**From:** NICKY DONNELLY <nickydonnelly@btinternet.com>  
**Sent:** 22 May 2018 14:01  
**To:** planning  
**Cc:** Barbara Green CPC  
**Subject:** Fw: Application 3/2018/0303 Croftlands Chipping

**From:** Cllr Simon Hore  
**Sent:** Saturday, May 12, 2018 01:03 AM GMT Standard Time  
**To:** Stephen Kilmartin; planning  
**Cc:** Cllr A. Brown  
**Subject:** Application 3/2018/0303 Croftlands Chipping

Application 2018/0330 is a follow on to 2013/0571 which was approved on 3/3/2014 despite being opposed by the Parish Council. Four years on there are 2 partly developed houses ( plots 2 and 3) and these have been incomplete for around 3 years. Plot 1 was opened up late last year and the access to the L of Croftlands is a mess.

SITE PLAN_AS PROPOSED

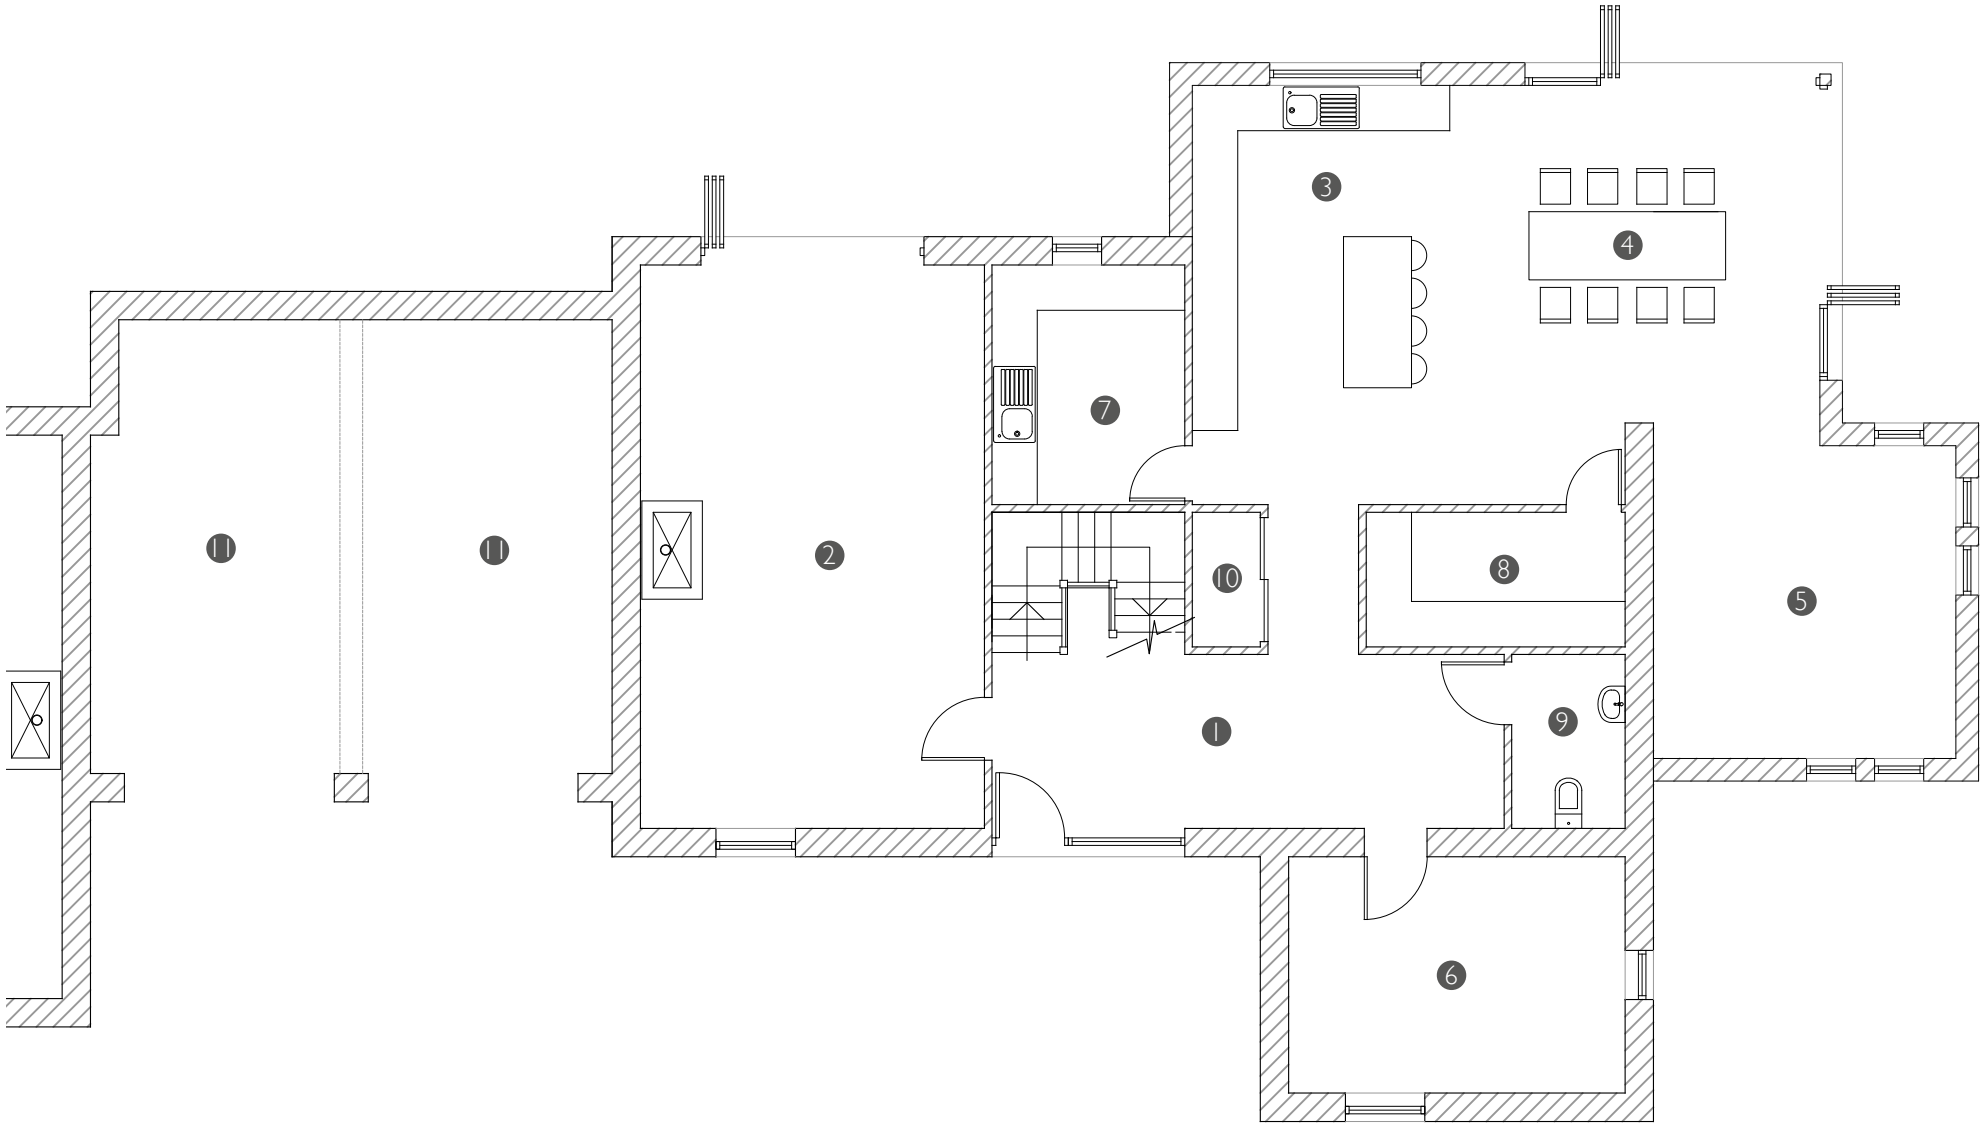
3.9 The schematic drawing indicates the Field Access Track shown as note 3 on the site plan in the application. My concern is that this may provide future access to another application to the N side of the field!

Figure 2-1: Aerial image of Chipping, showing the location of the application site and Croftlands (source: Google Maps)

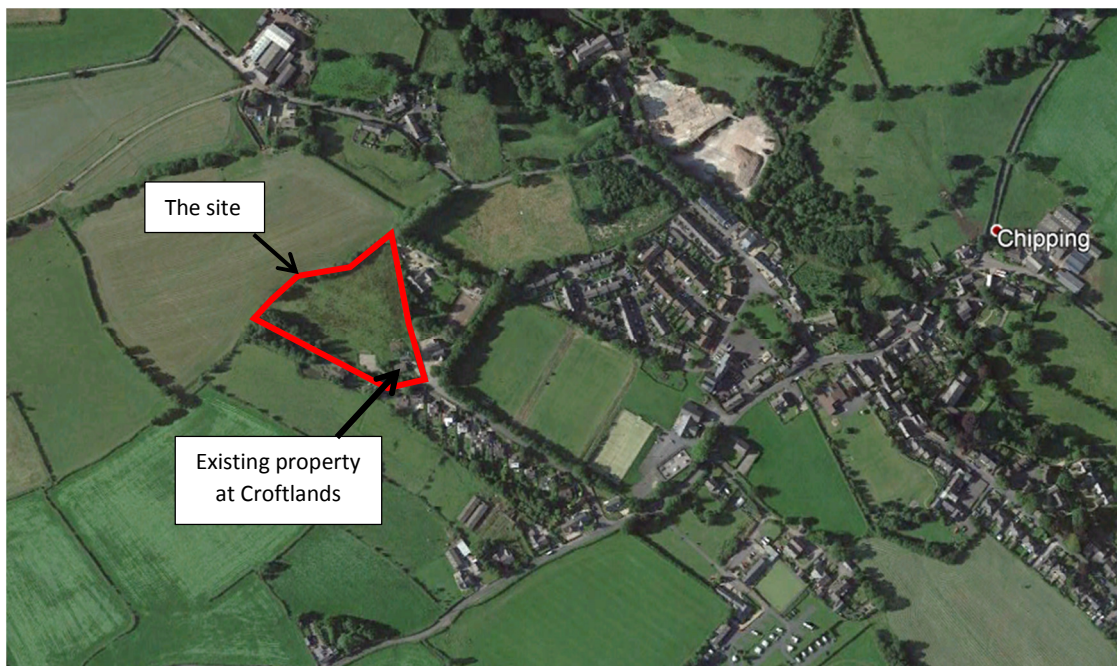
2.2 'land is marshy' - much of the uplands around Chipping and within Ribble Valley are similar and provide the mainstay of agricultural land for sheep farming. It therefore could continue quite adequately as farming land as the applicants have used for many years prior.

Figure 2-2: Extract of the adopted Ribble Valley Proposals Map, showing the site within Chipping

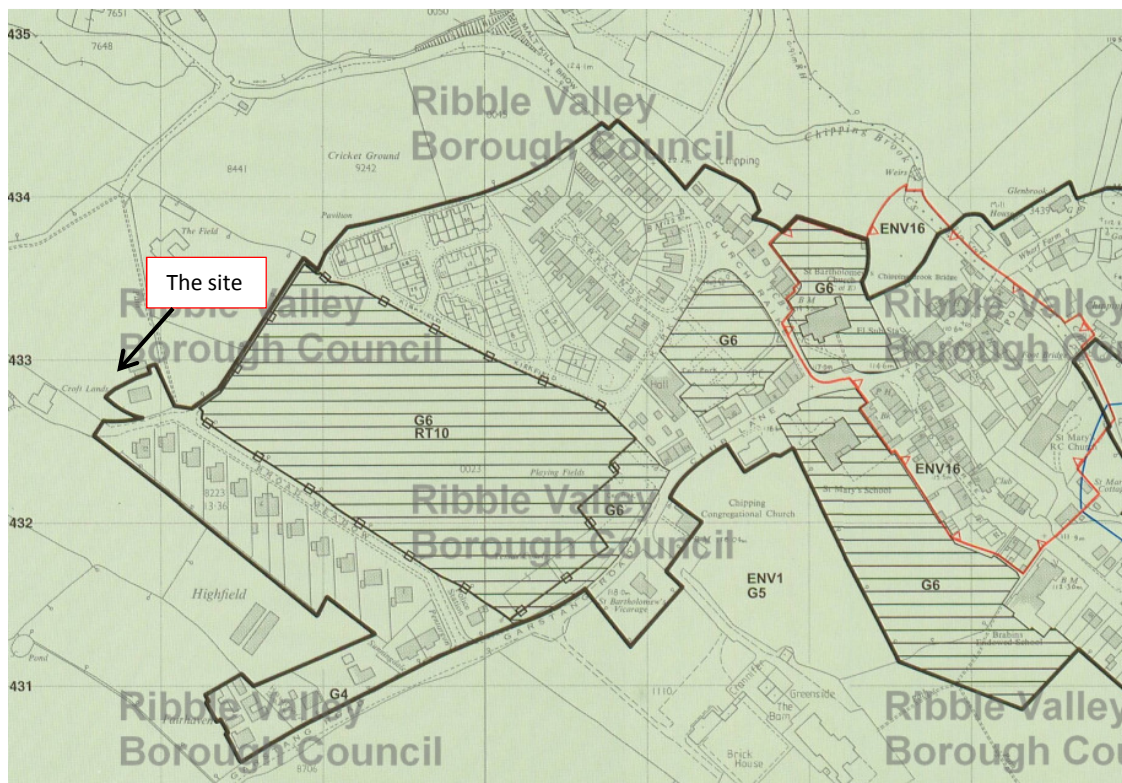
2.9. The development is outside the settlement boundary. Against DMG2 there is no special exception for this site and there is no local need or benefit.

Figure 2-3: Extract of approved site layout plan for planning permission 3/2013/0571 (source: Ribbles Valley Borough Council online application database)

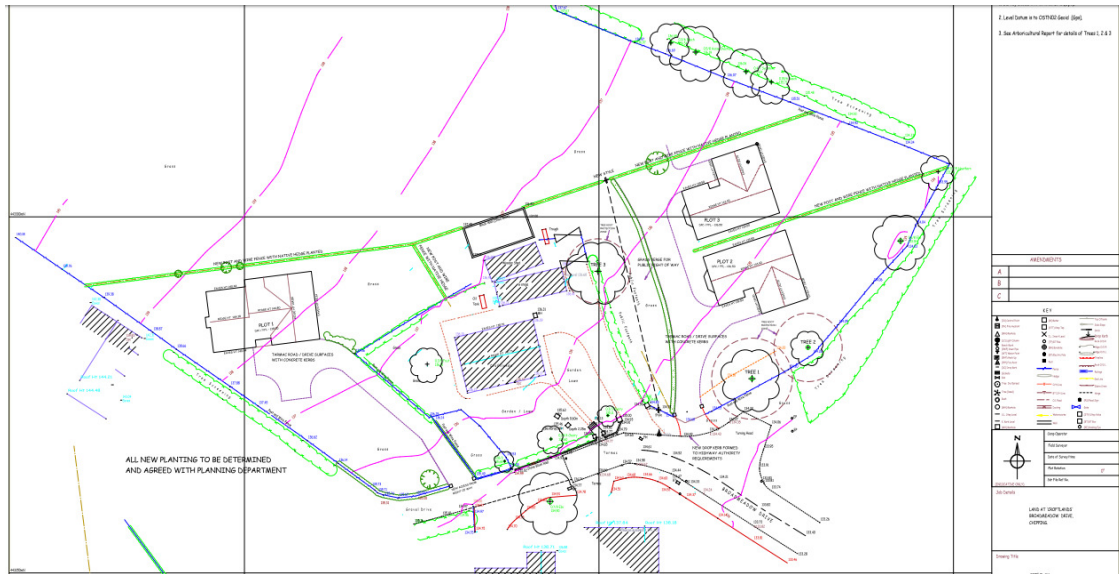
The applicants have made little attempt to complete the initial application. 2.25 confirm that footings were started belatedly on plot 1 (within the timeframe?). However this section does not declare that plots 1 and 2 are not complete.
